92 Crossbush Rd
Felpham
West Sussex
PO22 7LZ

Planning application ref FP/22/19/HH

REAR ELEVATION

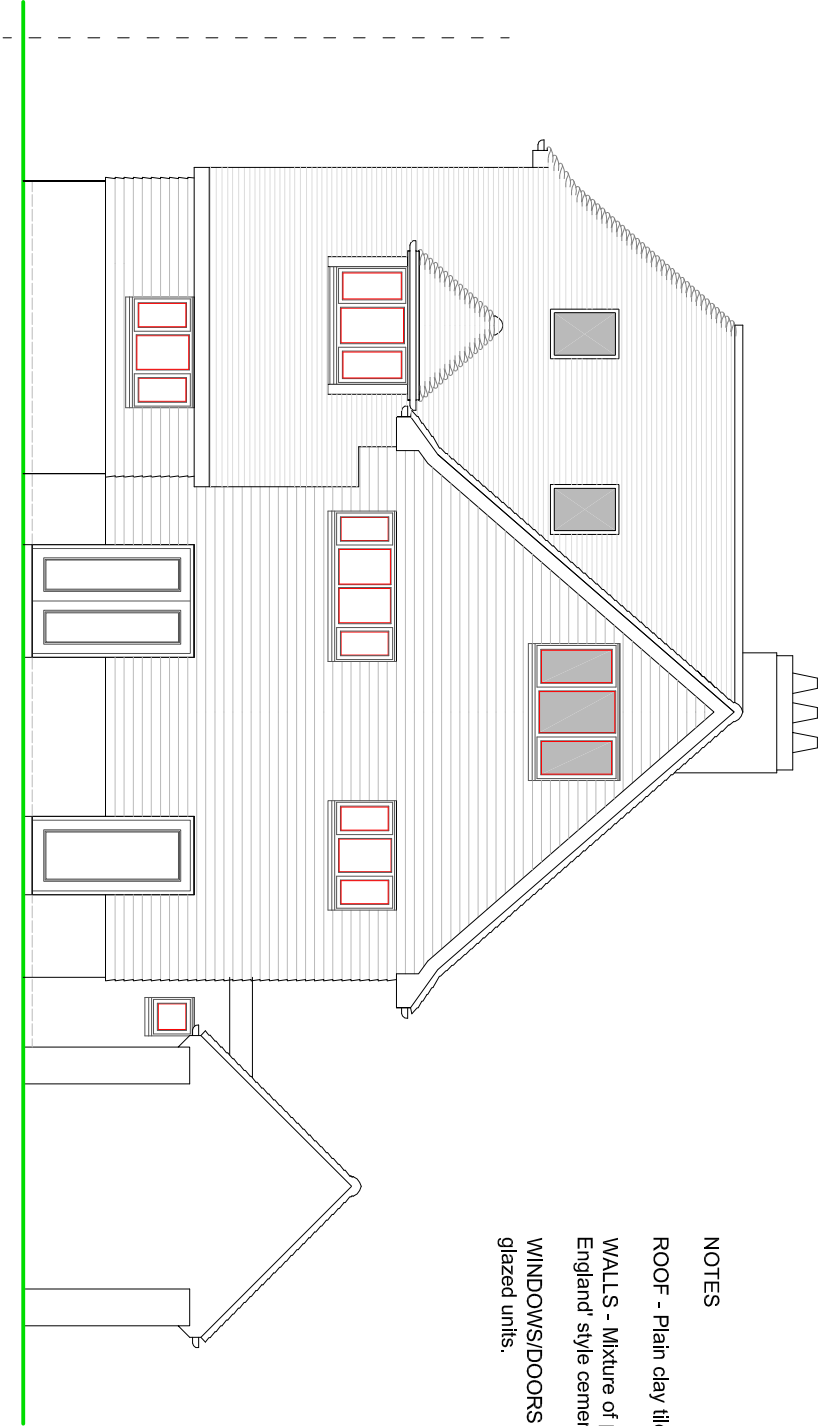
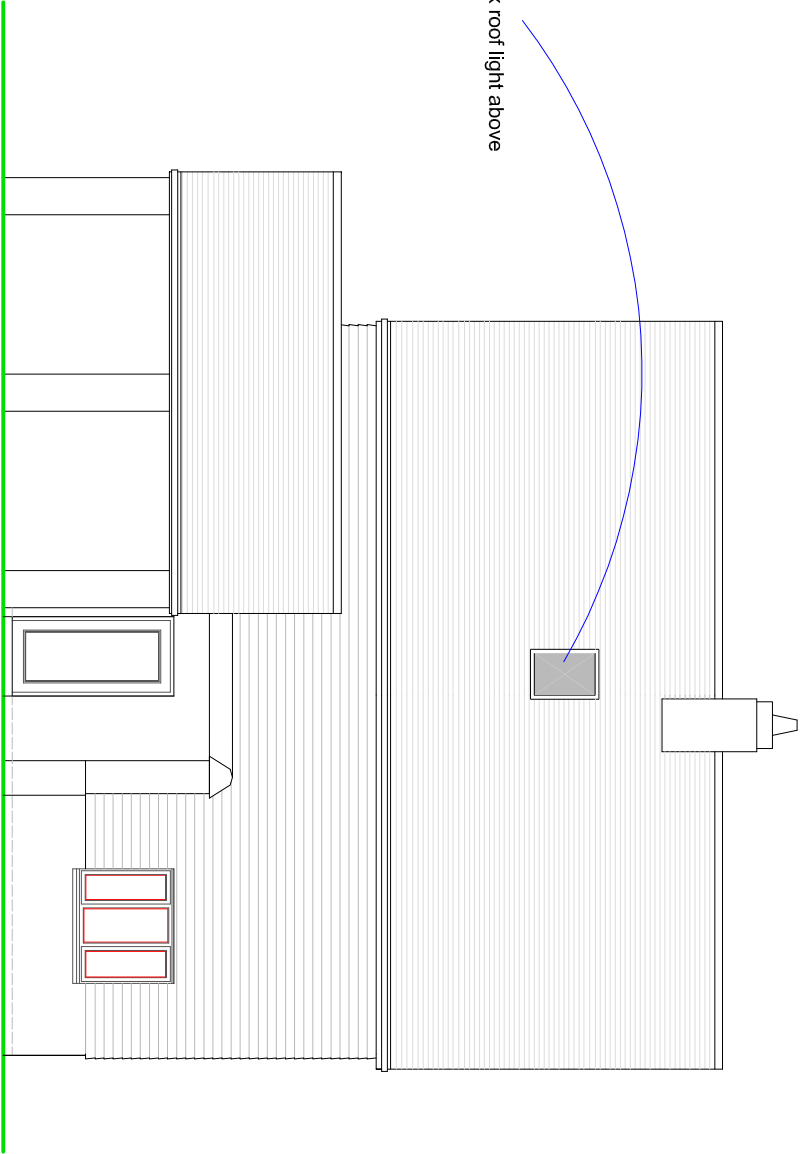
My major concern is the size of the rear window on the second floor, and the fact that it is on the vertical wall not the sloping roof. The back of my house, my kitchen diner, back bedroom upstairs and my side garden would be in the sightline from this room which I feel would result in a significant loss of privacy.
